Norwich to Tilbury Examination Team

Historic England ExQ1

Your ref: EN020027

Please find below our response to the specific ExQ as set out in the **EN020027-002163-Examining Authority's Written Questions 1** document

Norwich to Tilbury  
Figure: 7.12.F232\_HE24c  
Viewpoint HE24: Church of St Marys Washbrook

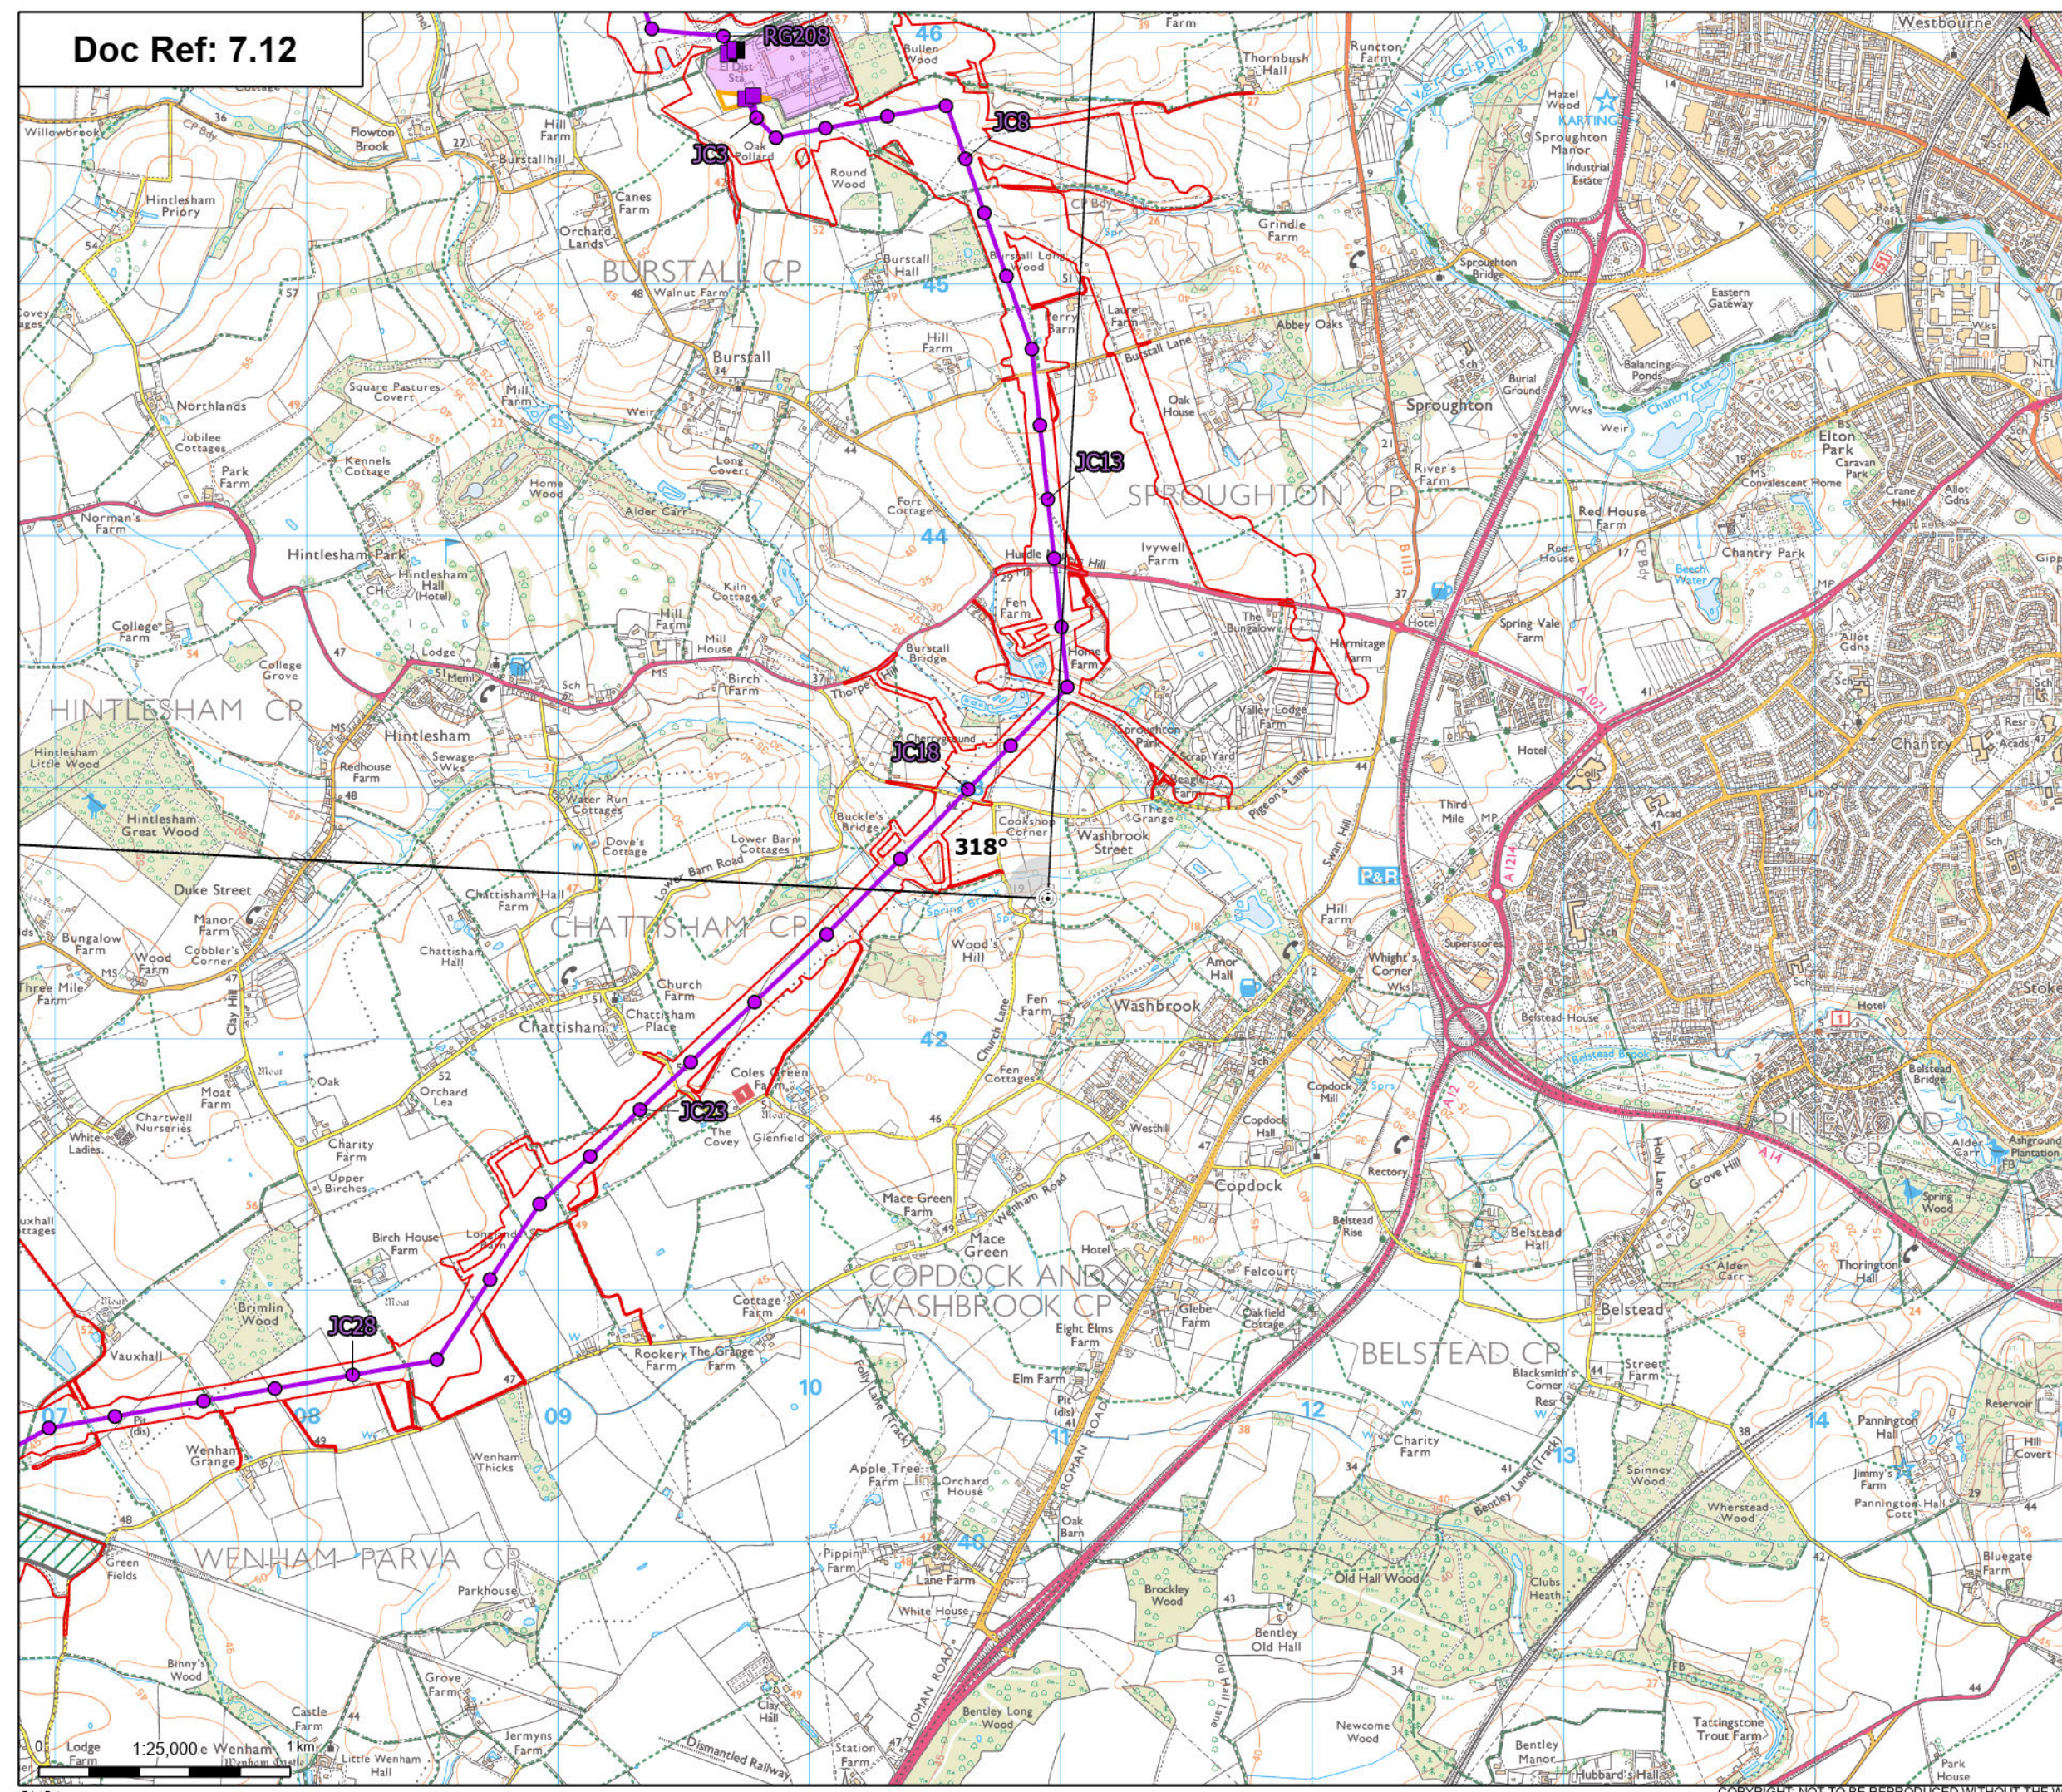
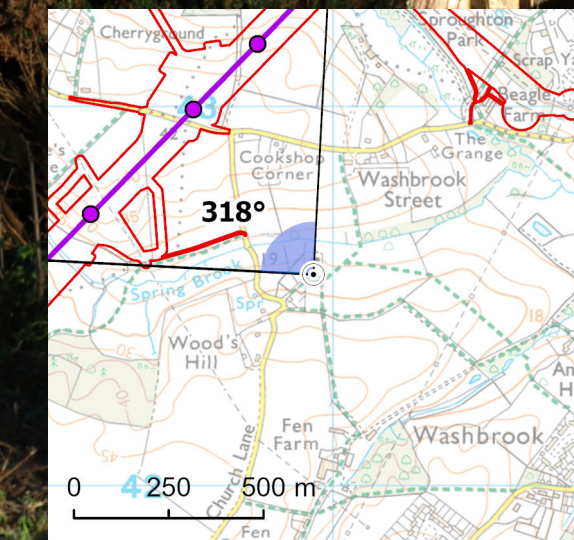
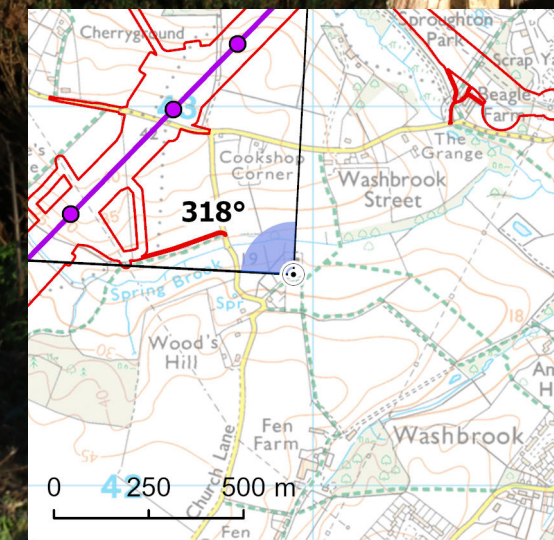
EXQ1 ref	Response required from	Question	HE response
HE1.12	All local authorities Historic England	<p>Heritage visualisations - 1</p> <p>A range of heritage visualisations are provided [APP-350] and [APP-351].</p> <p>All local authorities and Historic England are asked to confirm:</p> <p>a) Agreement with the viewpoints chosen to reflect any potential impacts on heritage assets.</p> <p>b) In your opinion are additional visualisations required, and if so from which assets and where should the visualisations be taken from?</p>	<p>In our written representations we have commented on a number of heritage assets where we have questioned the detail of the applicant's assessment of the impact of the proposed development on their significance, including the location of viewpoint images.</p> <p>We do generally concur with the majority of the viewpoints and even where we have a difference of opinion, in most cases we agree with the applicant's conclusions about impact. We are therefore content with the viewpoints overall.</p> <p>There are however four assets where we would welcome amended or additional images in order to support the examination and provide additional evidence on the likely impact. These are set out below.</p> <p>Roydon Hall (NHLE no. 1033215) and barn to NW (NHLE no. 1284584). We have previously requested the applicant provides a viewpoint looking from west of this complex to include the front of the Hall and from a suitable location to show the appearance of the proposed pylons behind the listed buildings to the east.</p> <p>Creting Hall (NHLE no. 1352073). We do not consider the supplied viewpoint (VPHE35) sufficient to illustrate the potential visual impact on the listed building. This image, taken in the rear garden of the listed house from where pylon RG164 would be some 190 m away, suggests it would be screened by vegetation on the garden boundary. However,</p>

<p>in this precise view the upper part of the pylon seems to be masked by trees. It is possible it would be more clearly seen by moving the viewer slightly to the left and slightly raising the view. From that viewpoint the pylon might be clearly seen and given the distance have a pronounced, even dominant effect. An additional image might better illustrate this. We have also noted that another additional viewpoint taken from a location to the west of the Hall on the higher ground could show the proposed pylons to the east of the building which could illustrate the impact on its landscape setting.</p> <p>Chobbings Farmhouse (NHLE no. 1306286). The applicant's assessment states that the setting of this asset does not extend to the order limits. However, we consider that views of the proposed pylons would be possible from the rear of the property with the potential to have a visual impact. A viewpoint image from the rear, looking towards the order limits and selected to avoid the thickest vegetation on the boundary would illustrate this effect.</p> <p>Hylands Park (NHLE no. 1000197). The applicant's assessment has not considered the potential visual impact on the western side of the Registered historic park. Should the applicant review this a viewpoint image from the western edge of the park looking towards the proposed pylons could be helpful in establishing the effect.</p>
